Application for removal or variation of a condition following grant of
planning permission. Town and Country Planning Act 1990.
Planning (Listed Buildings and Conservation Areas) Act 1990

Reserved matters application for the erection of 8no. dwellings (pursuant to planning permission 18/0708/OUT)

19/0726/RESM

Draw No.
182071-P4006

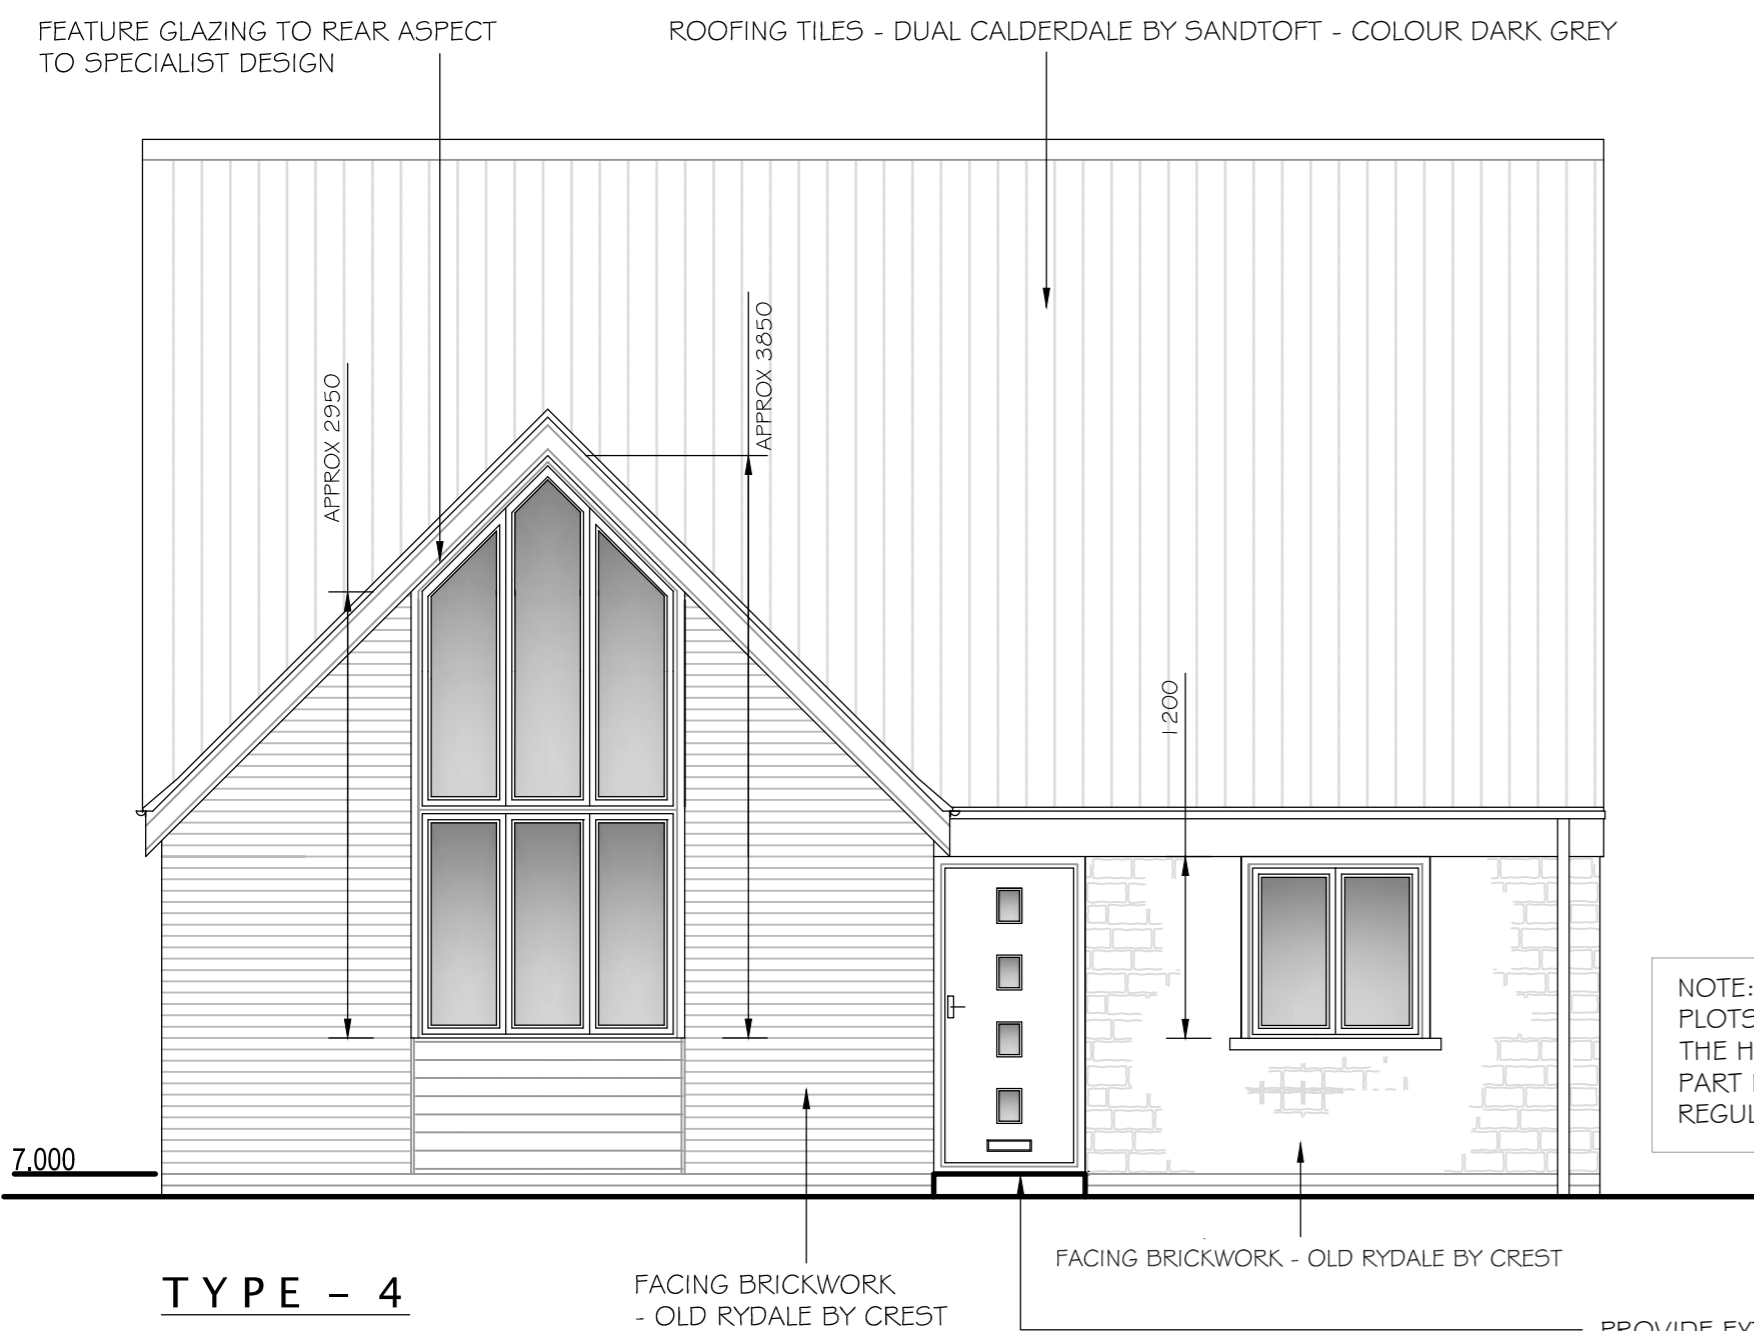
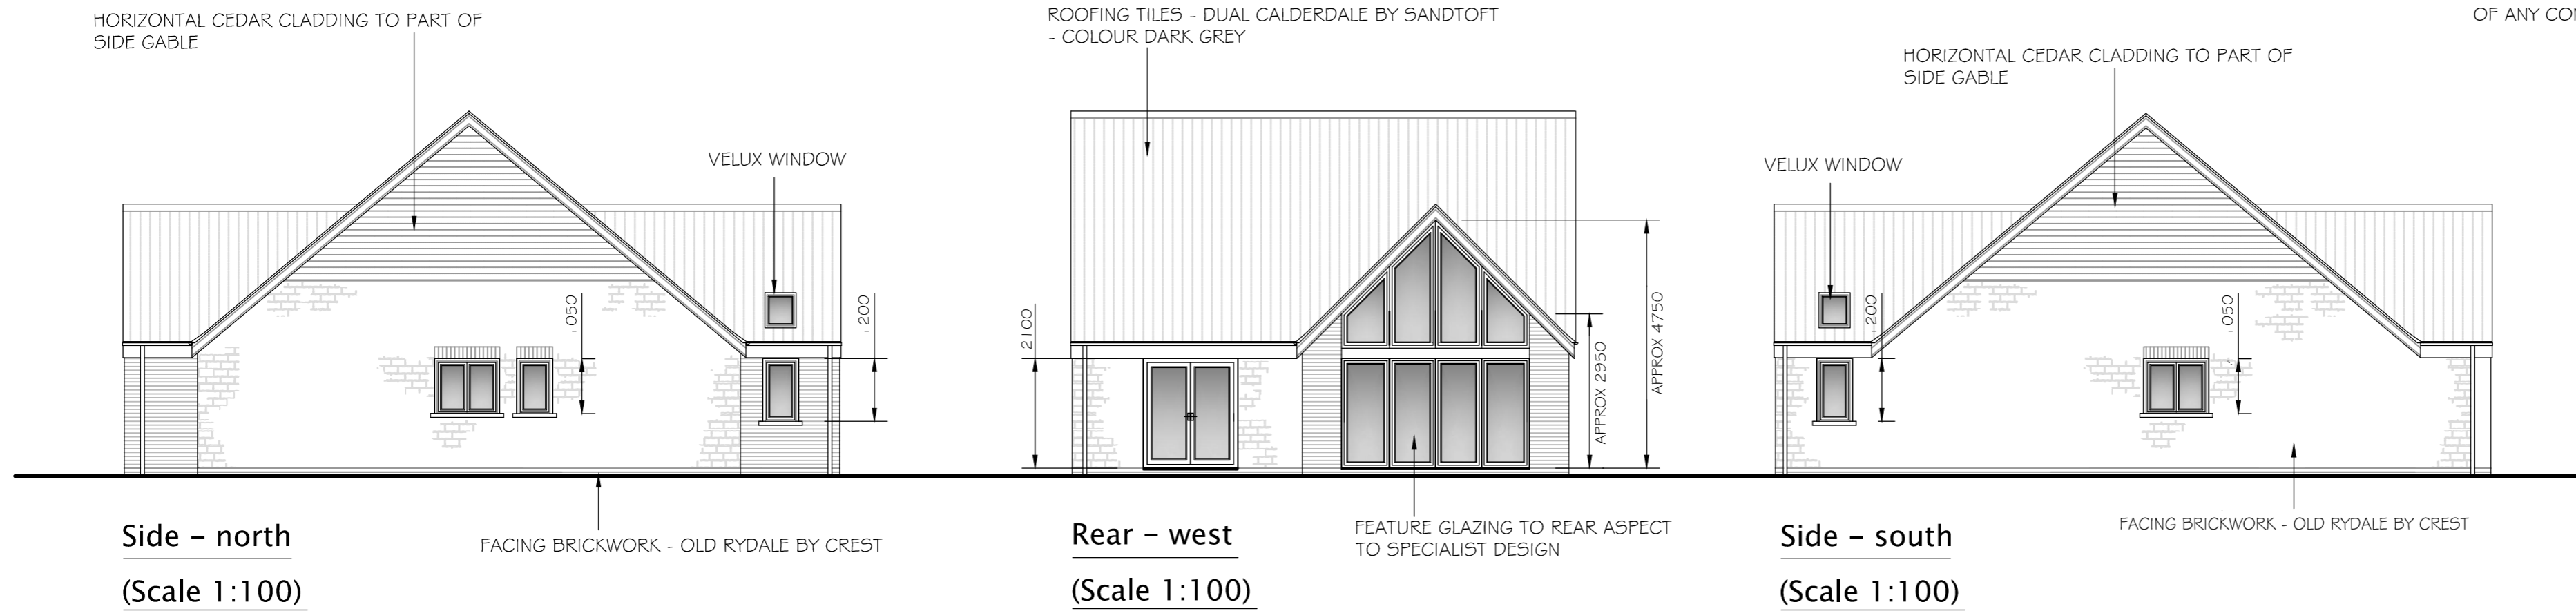
Condition 2 - We have decided to remove the natural stone from the external materials on house number 4 (drawing number 182071-04) and house number 7 (182071-07).

Condition 2 - This will be replaced with the brick type that has already been approved for the other elevations of the houses and also match the other houses in the scheme. Superseded drawings are now numbers 182071-P4006 (Plot 4) and 182071-P7006A (Plot 7).

Title
Adoptable Drainage Longsections

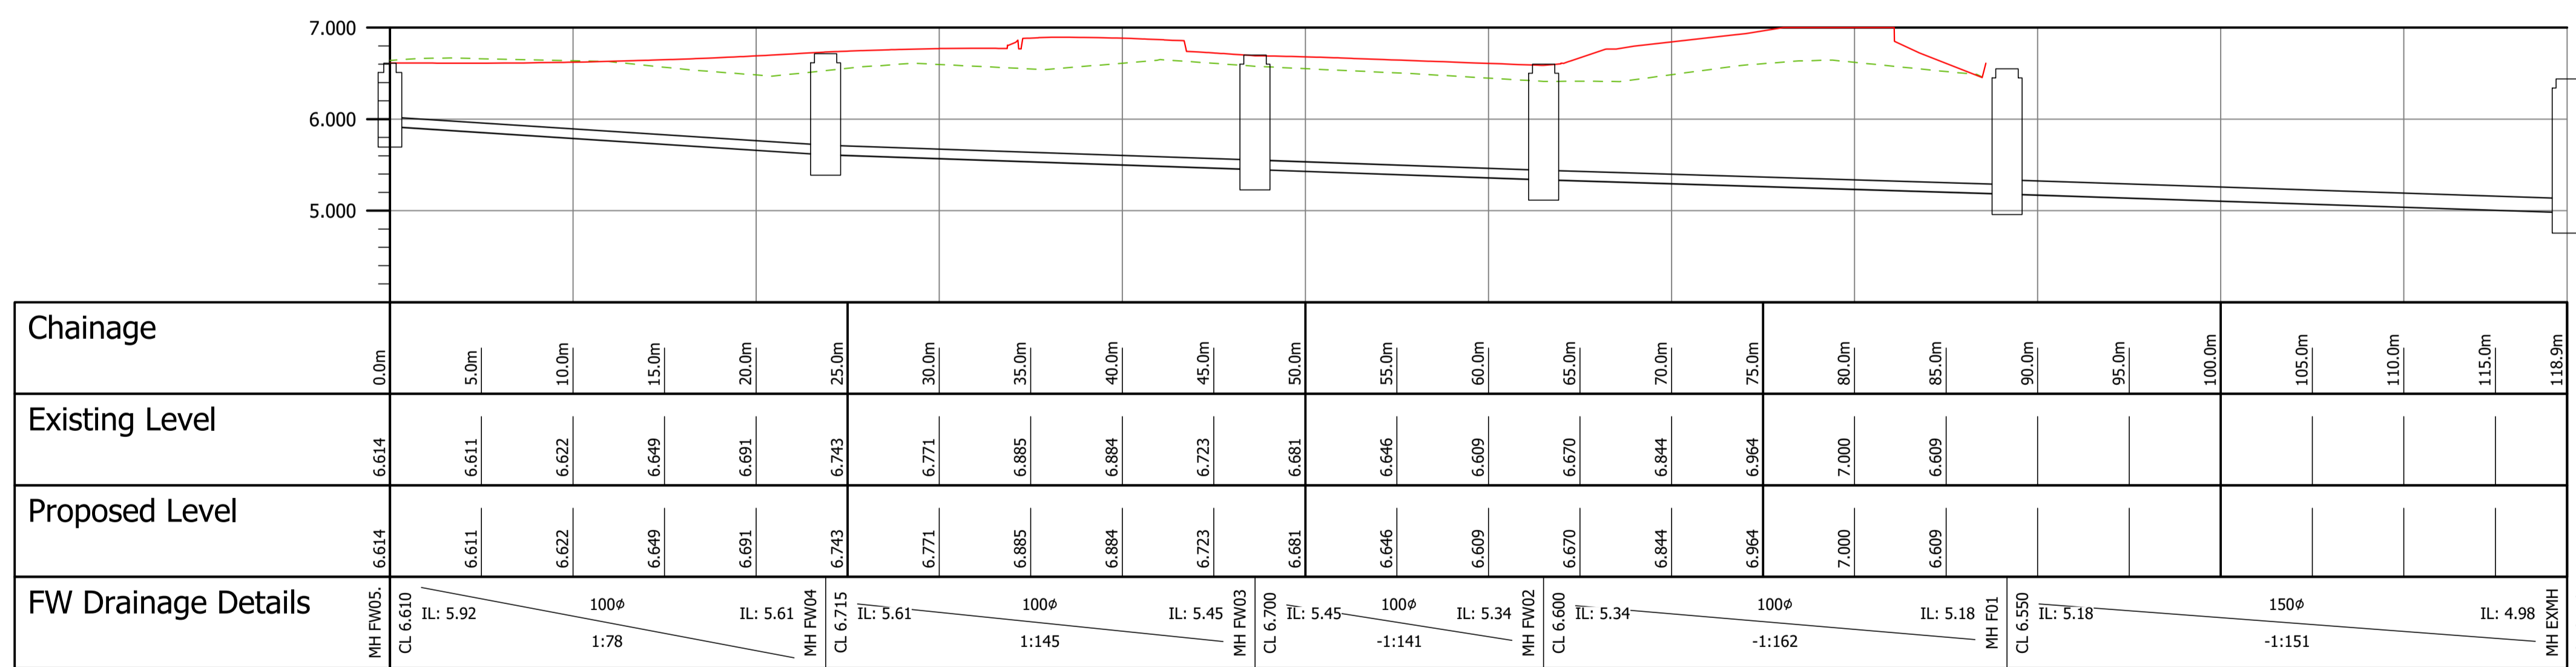
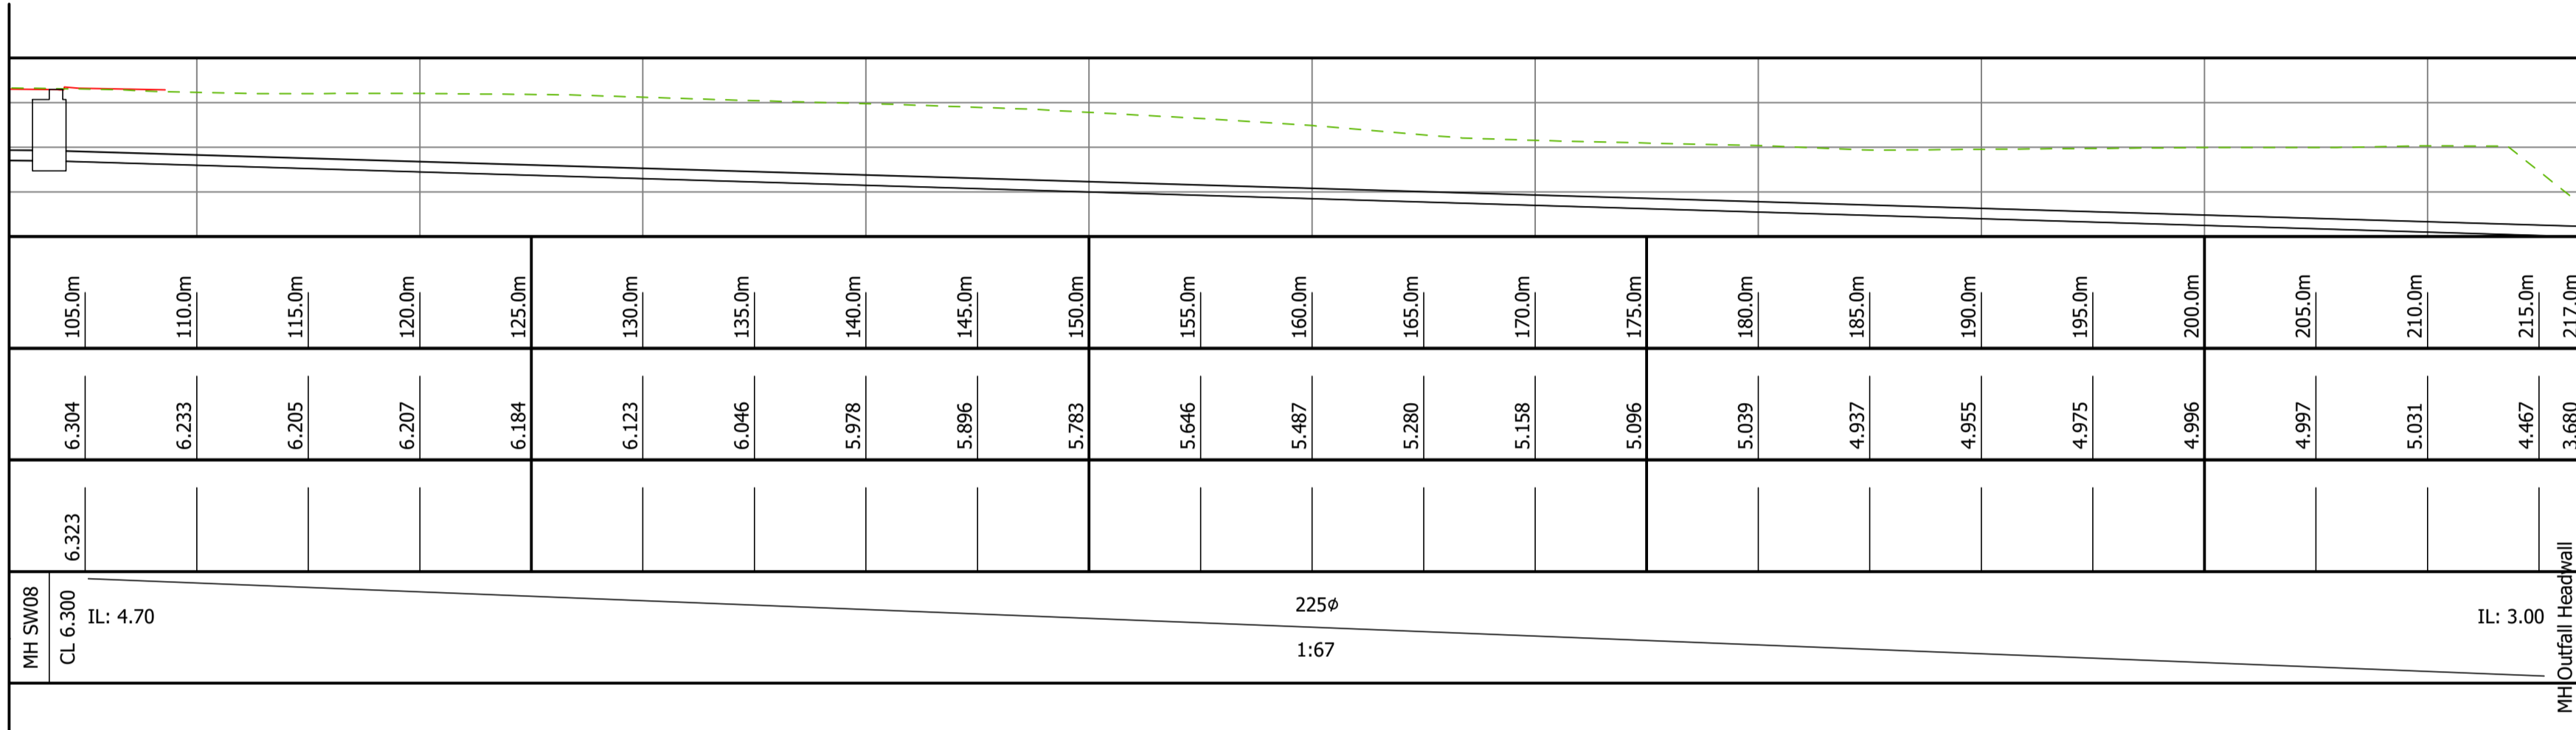
Condition 7 - We have been able to agree a Deed of Easement with a neighbouring property to go through their garden and access the Foul Water Drain in Orchard Close. Therefore the pumping station is no longer required and will create a better overall aesthetic impression for the scheme. Technical approval has been obtain from Anglian Water for this revision/variation.

Condition 7 - With the removal of the pumping station, we have created an easement to go through a neighbouring property. In order to create the 6m wide easement, we had to replace the double garage shared by plots 5 and 6, with a single garage for plot 6 only and the addition of a single garage to plot 5. Plot 6 also had to move south slightly to accommodate the easement. Superseded drawings are now numbers 182071-P9002A (site plan), 180419-WDK-00-SI-DR-C-33000-P06-Section 104 Adoptable Drainage Plan, 180419-WDK-00-SI-DR-D-33200-P03-Adoptable Drainage Manhole Schedule and 180419-WDK-00-SI-DR-D-33300-P03-Adoptable Drainage Longsections.
